REQUEST

Current Zoning: N1-A (Neighborhood 1-A)
Proposed Zoning: N1-C(CD) (Neighborhood 1-C, Conditional)

Approximately 4.75 acres located east of Moss Road, south of Livingston Mill Road, and north of Scottsman Trace Drive.

The petition proposes to develop a vacant, wooded property in the Steele Creek community with 21 triplex dwelling units.

REZONING NOTES, RZP–2025–025

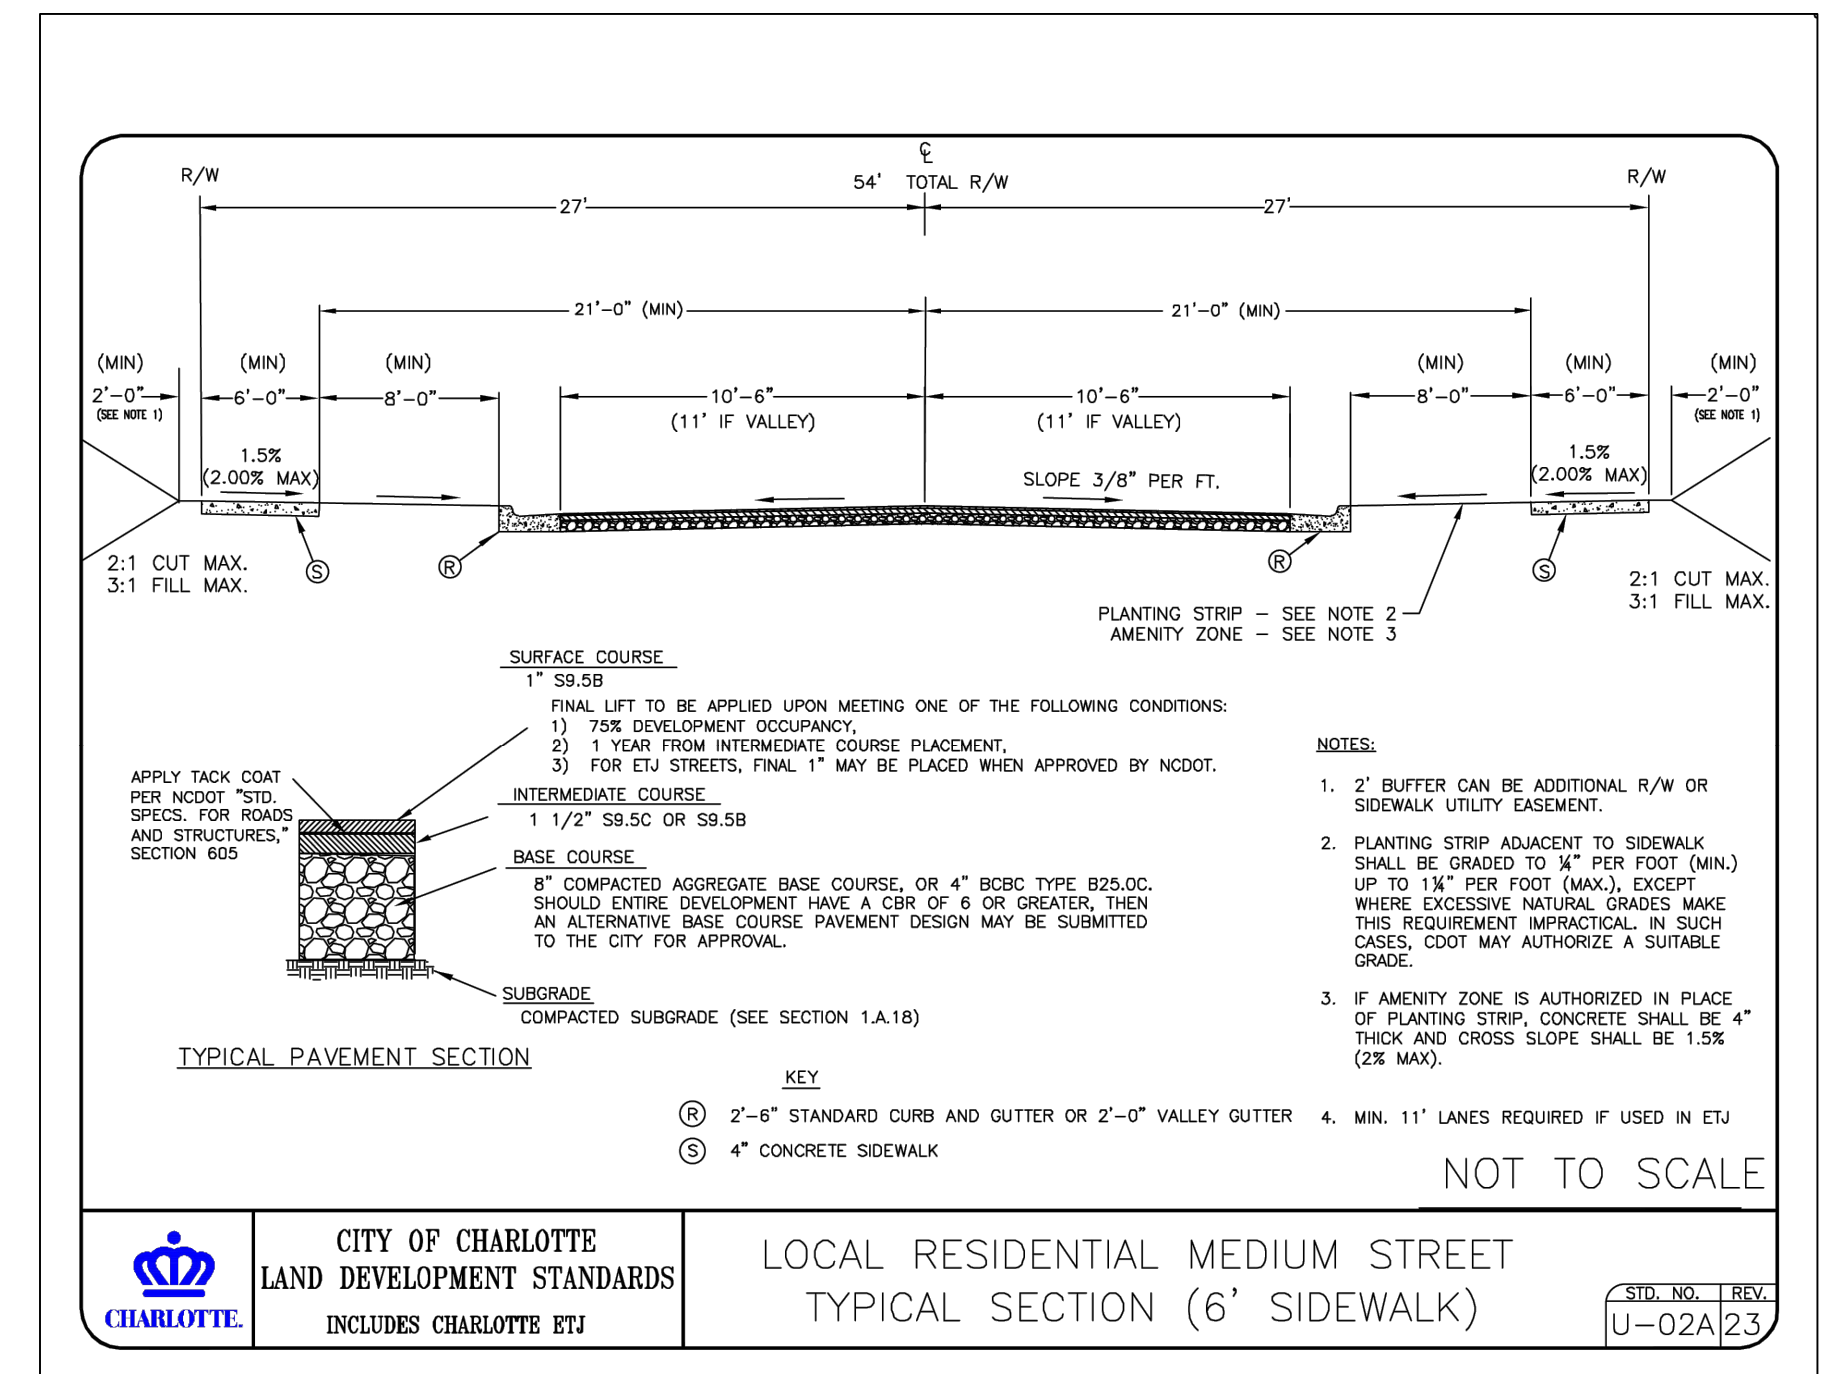
1. ~~Remove all note references to multi-dwelling developments, which are not permitted in the N1-C zoning district.~~ **ADDRESSED**
2. ~~Revise max building coverage note from 40% to 50%.~~ **ADDRESSED**
3. ~~Label and dimension front and rear setbacks and lot width.~~ **ADDRESSED**
